2024/0825**Applicant:** Mr L Lawrence**Address:** 18 Alton Way, Staincross, Barnsley, S75 6EY**Description:** 2 storey side and rear extensions to 2 storey semi-detached dwelling

The proposal is for a two-story extension on the side and rear elevation of the dwelling. On the ground floor, the proposal would be a wraparound style extension but on first floor the side and rear extensions would not be joined. The plans indicate internal modelling to retain a three-bedroom dwelling, but due to layout, the proposal would realistically be a four-bedroom house.

Drawing Title
PROPOSED ELEVATIONS

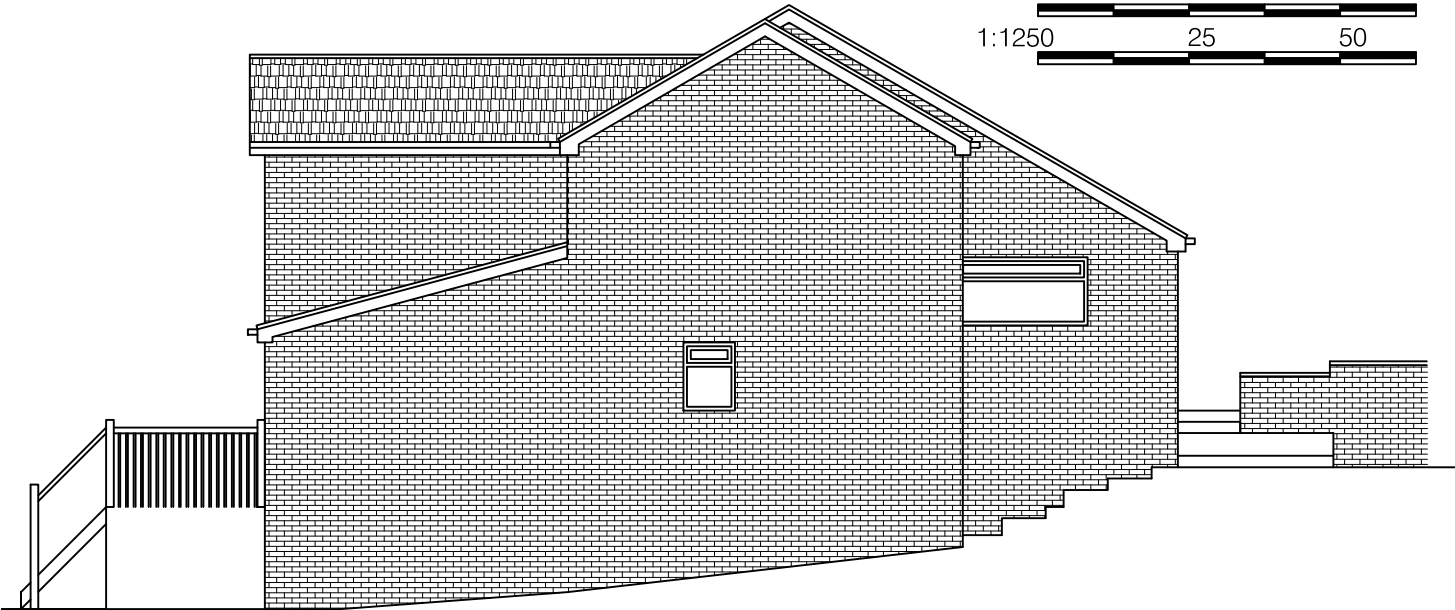
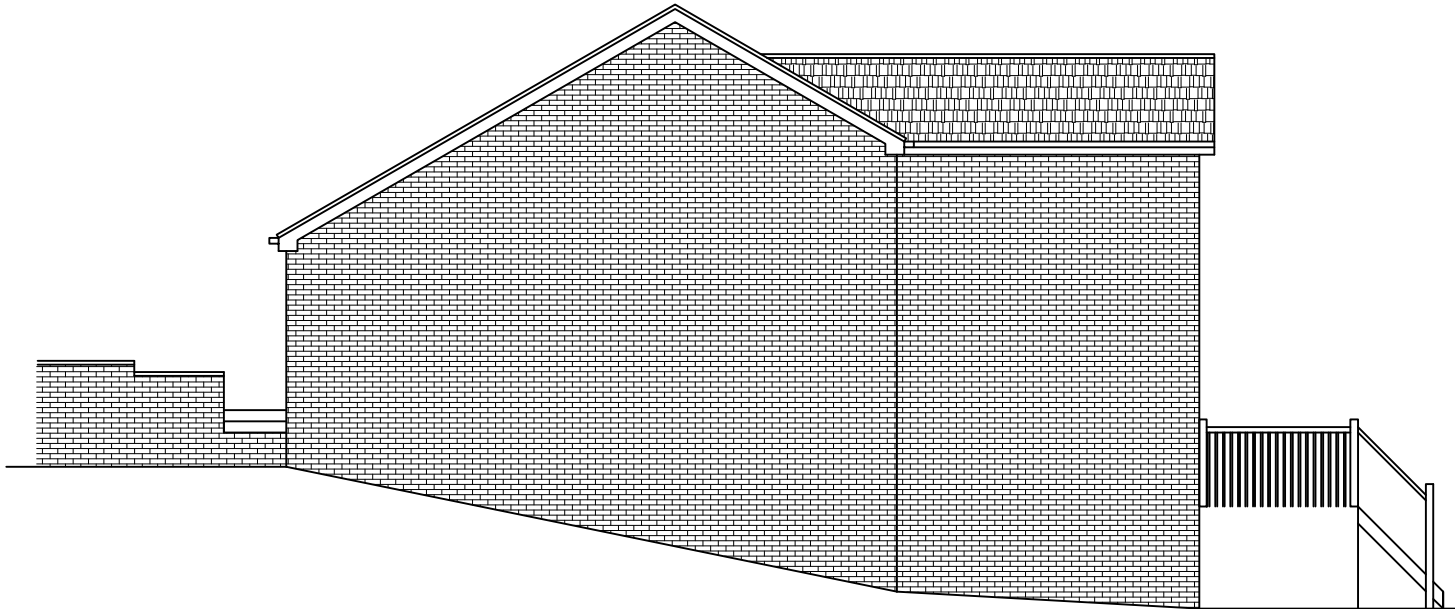
There is concern from a neighbouring dwelling about the potential overlooking of their garden from the proposed ensuite window in the side elevation of the side extension. Following checks of the plans, the proposed window would be approx. 4m away from the blank side elevation of the neighbouring dwelling, which it would also directly overlook. It would be assumed that an ensuite window would be installed with privacy glass, to ensure the privacy of residents of the dwelling, but this would be added as a condition of approval. With the window being a non-habitable room, not directly overlooking anything except a blank elevation and with a requirement for privacy glass, there would be minimal impact on the amenity of any nearby dwelling. There was also concern over potential retaining wall and a resulting narrow pathway of approx. 24 inches or 60cm between the side elevation of the extension, and their boundary, which is claimed to drop down between 3 - 5ft to their curtilage. Having checked the plans, there appears to be between 60 - 64cm gap at the tightest point of the pathway, with a standard sized wheelie bin having a width of 58 cm, although extremely tight, the residents, if they wished, would just be able to wheel a wheelie bin from and to the rear garden, assuming this is where they are stored. Whilst the potential drop is not ideal, it would actually prevent accidental trespass on to the neighbour's property. Regarding walls, if it was considered a party wall, as they may be internal or external, this would be a civil issue between the neighbours.

With similar materials being proposed and a varied street scene of extended dwellings on Alton Way, whilst there would be some impact upon the street scene, the proposals would not have a significantly adverse effect upon the visual amenity of Alton Way. On the front elevation what is proposed to be an open storage area, because of the levels, this should not be significantly noticeable. A similar scenario would be applicable to the view of the rear elevation. Because of the dominant position of Alton Way, many of the rear elevations of dwellings are visible from streets such as Kingsway. In mitigation of this, a large proportion of dwellings visible from Kingsway have also been extended, some significantly as is proposed with this dwelling. Because of the trees between the application dwelling and those on Kingsway, unlike other dwellings, the view of the application dwelling would be diffused.

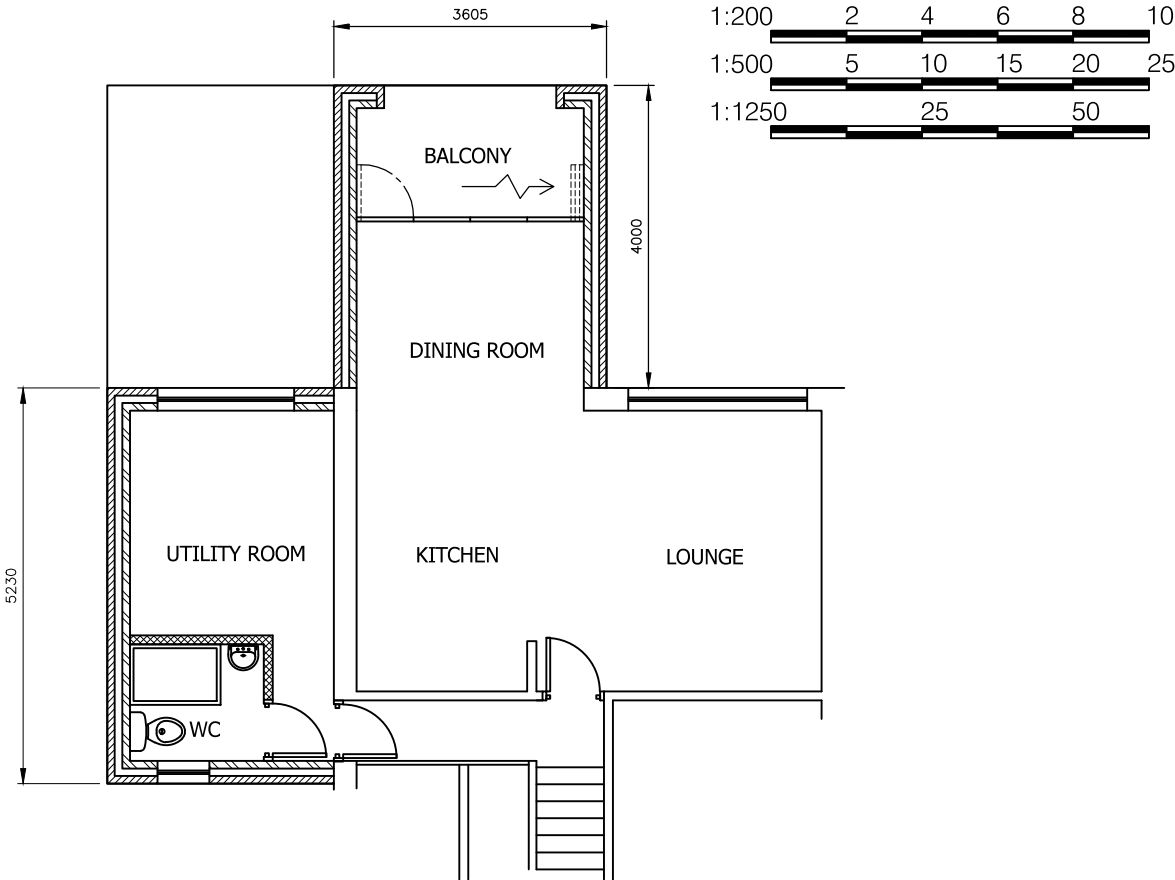
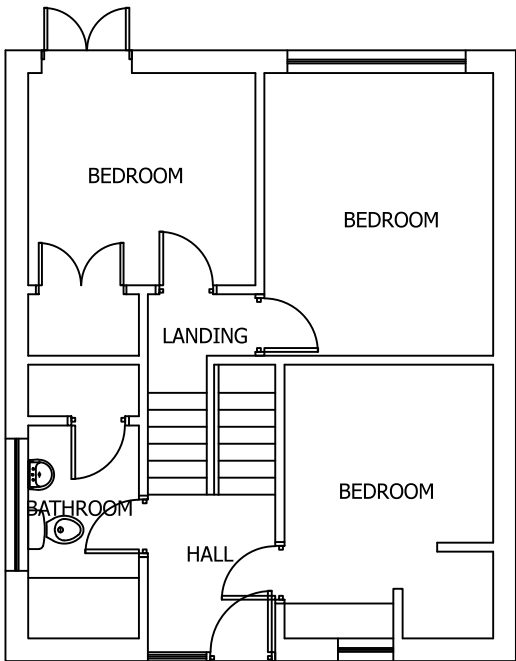
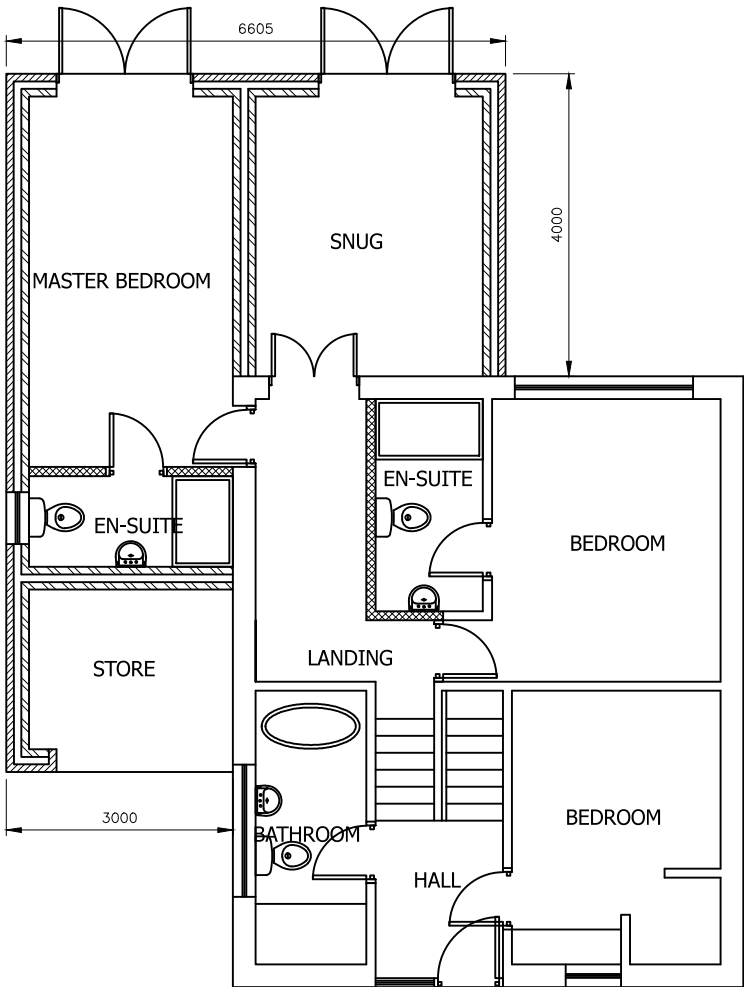
Although the plans indicate three bedrooms, there is a possibility of a room being utilized as a fourth bedroom. However, as there are no proposed changes to access or parking arrangements, and with policy requirements for parking provision being the same for a three or four-bedroomed dwelling, there would be no impact upon parking provision requirements or highway safety.

The proposal is undoubtedly large but has been designed to minimise the impact upon neighbouring dwellings with features such as the 'missing corner' of the first-floor extension to reduce overshadowing of the neighbouring dwelling and to reduce the impact of the extension becoming significantly overbearing. A balcony has been included but this has been constructed as an internal balcony to restrict overlooking of neighbours to the side of the dwelling whilst overlooking of neighbouring gardens beyond is ultimately unavoidable but sufficient distance in line with requirements remain in relation to distance to the boundary and to the habitable windows of neighbouring dwellings beyond. As with other extended dwellings on the street, there would be some impact to the street scene but not anything more significant than which has already occurred.
